Application for a non-material amendment following a grant of planning permission.

RESUBMISSION TWO STOREY EXTENSIONS, DETACHED GARAGE, HARDSTANDING INCLUDING VEHICULAR ACCESS, INSTALLATION OF SOLAR PANELS AND CHIMNEYS

DM/22/03466/FPA

DUE TO THE CONSTRUCTION OF THE TWO STOREY EXTENSION ROOF IT WAS NOT POSSIBLE TO BUILD THE INTERNAL STONE CHIMNEY. A 150MM CONSERVATION BLACK TWIN WALLED FLUE HAS BEEN INSTALLED AS THE ONLY ALTERNATIVE.

Proposed First Floor/Boundary

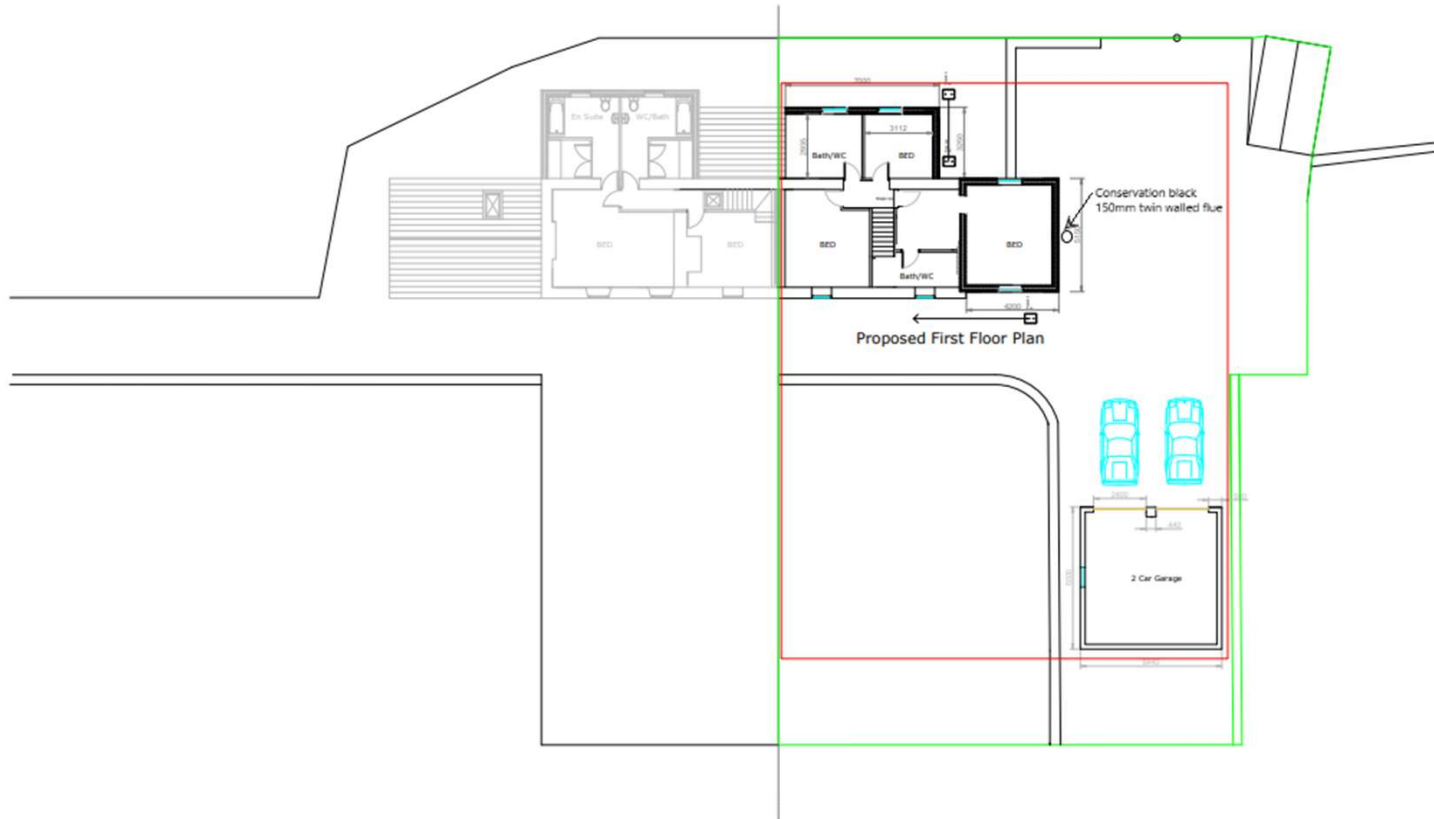
IT WAS NOT POSSIBLE TO BUILD AS PLANNED DUE A STEEL BEAM ON THE ROOF RIDGE. IT COULD NOT BE INCORPORATED INTO THE CHIMNEY.
